REQUEST

Current Zoning: R-3 (single family residential)
Proposed Zoning: R-8MF(CD) (multi-family residential, conditional)

Approximately 48.09 acres located south of North Tryon Street, east of Trevi Village Boulevard, and north of University City Boulevard.

The petition proposes to allow a residential community with 285 townhomes on a parcel of vacant land, located south of North Tryon Street and bordered by Cabarrus County to the east.

HUDSPETH 2 (AHS)
12300 N TRYON STREET
CHARLOTTE, NORTH CAROLINA 28204

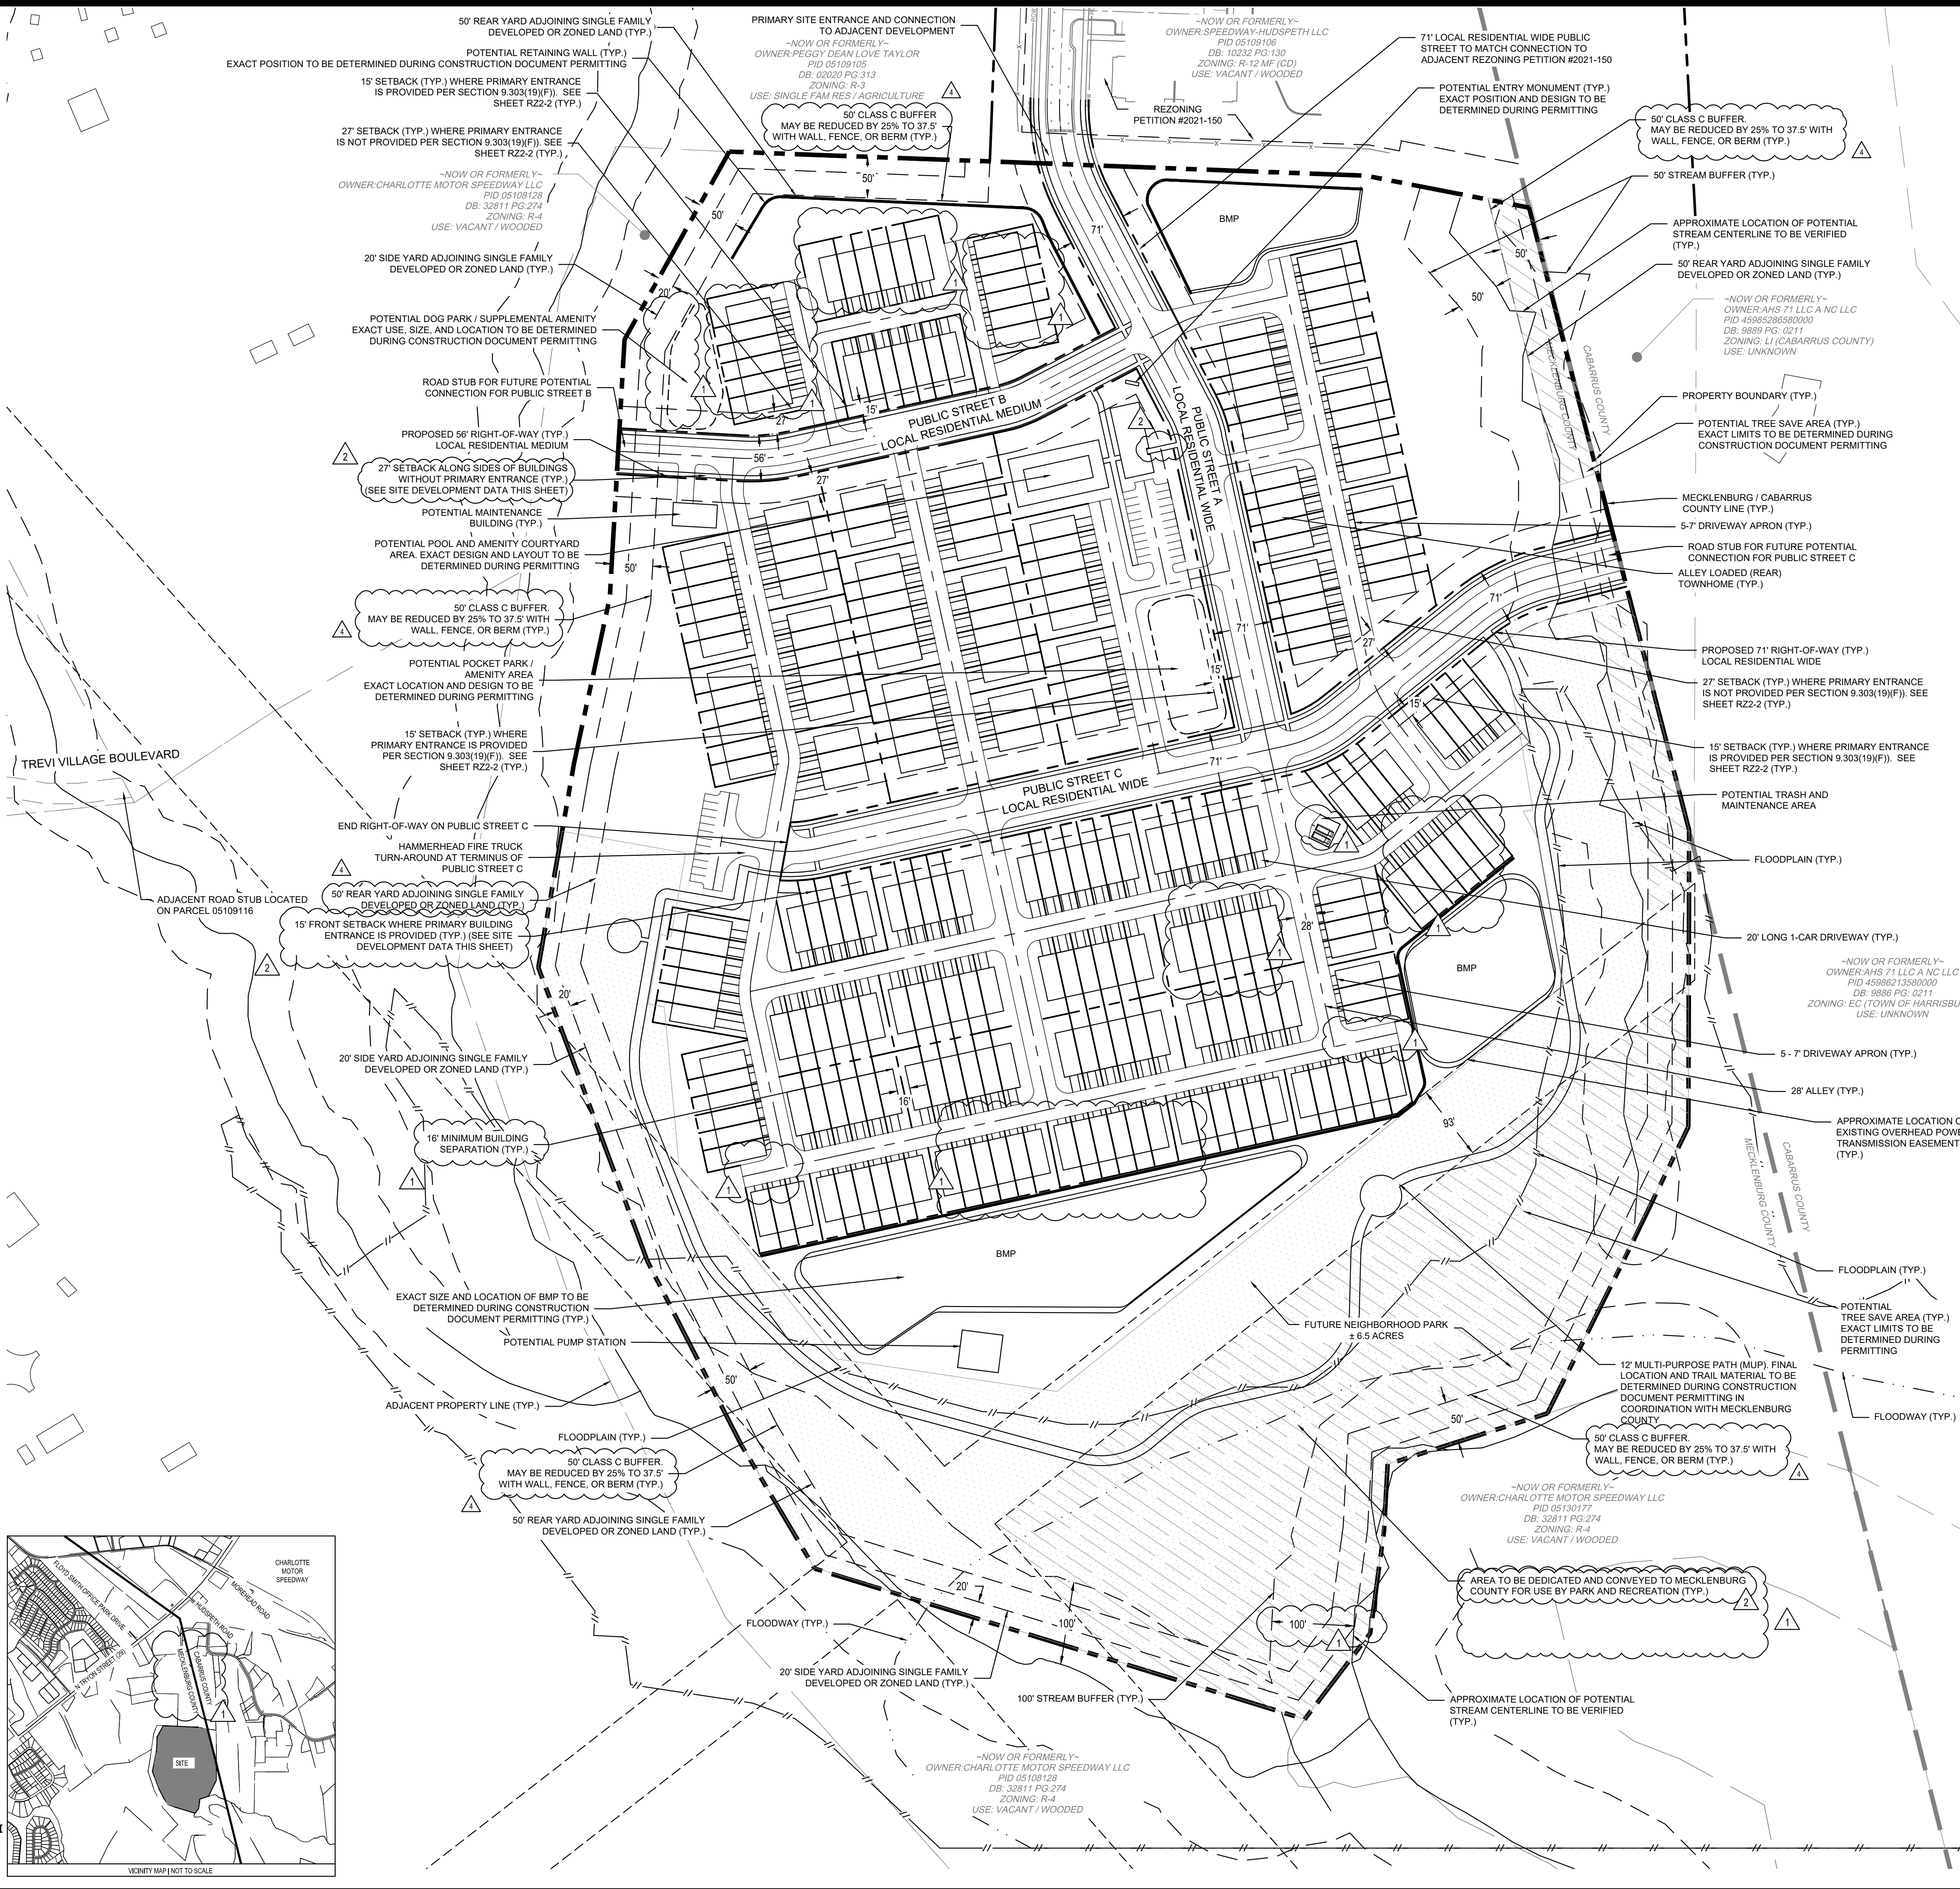
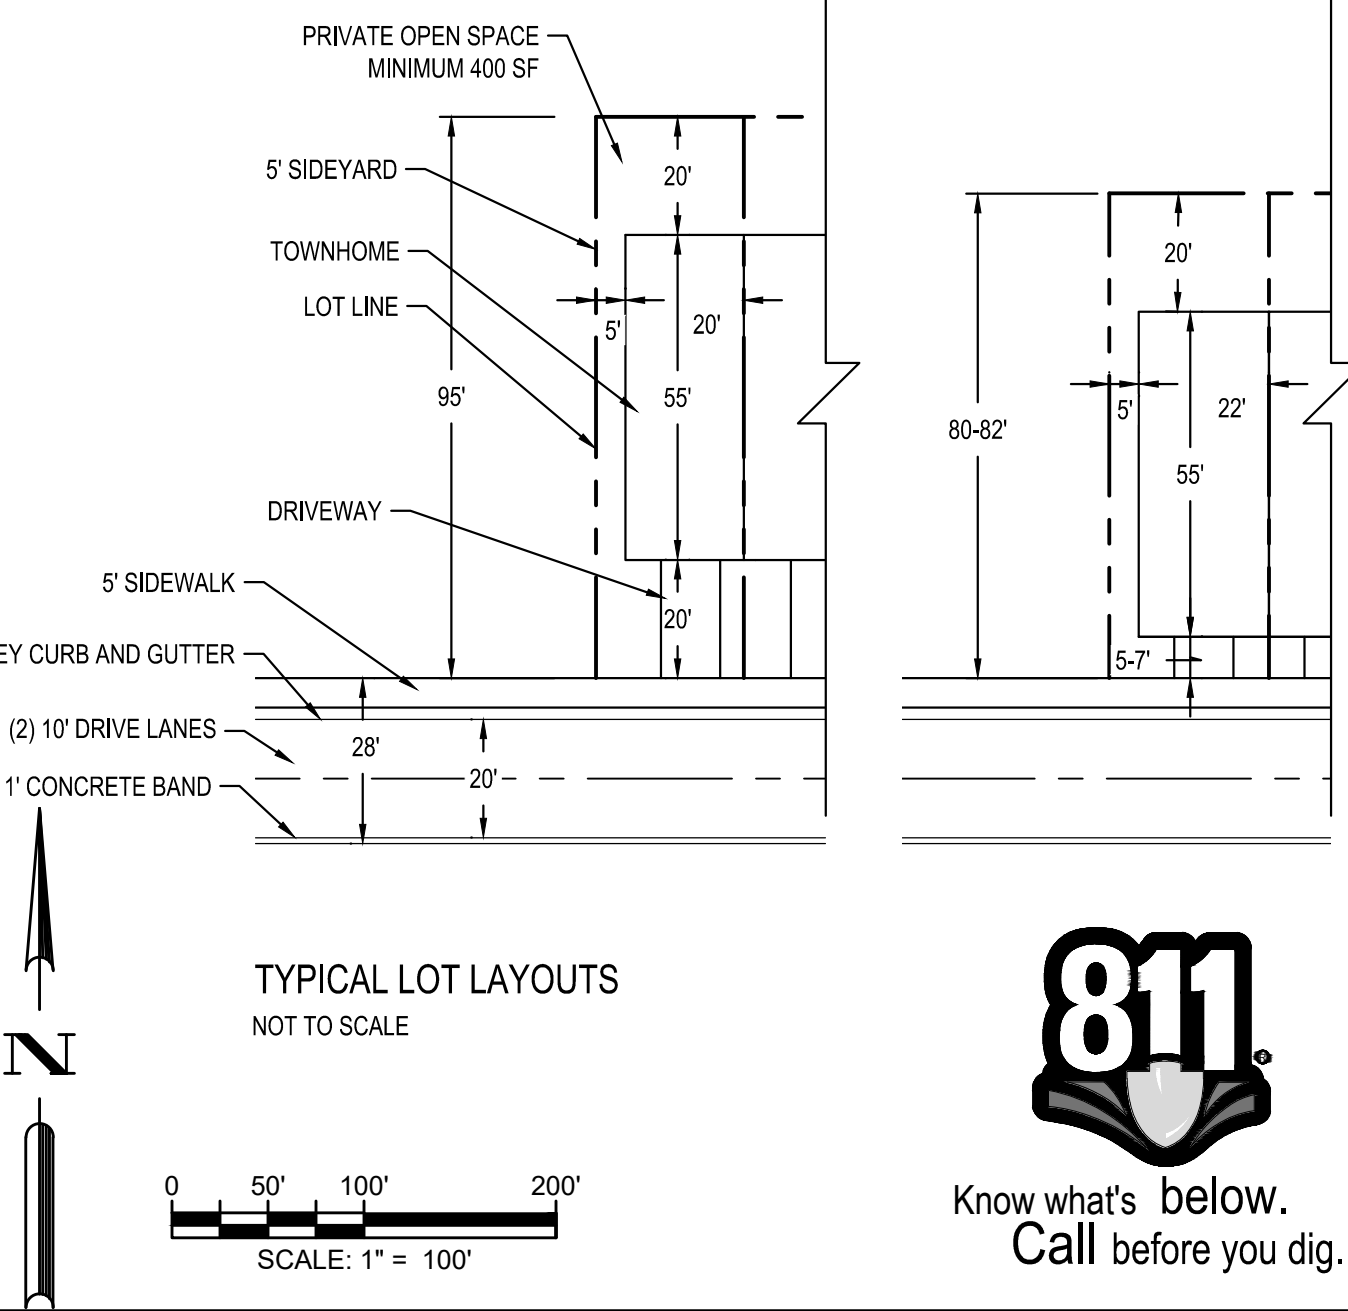
2. ~~Amend labeling on Class C buffers illustrated on plan to state they may be reduced 25% with wall, fence or berm, not buffer, berm, or fence.~~ **Addressed**
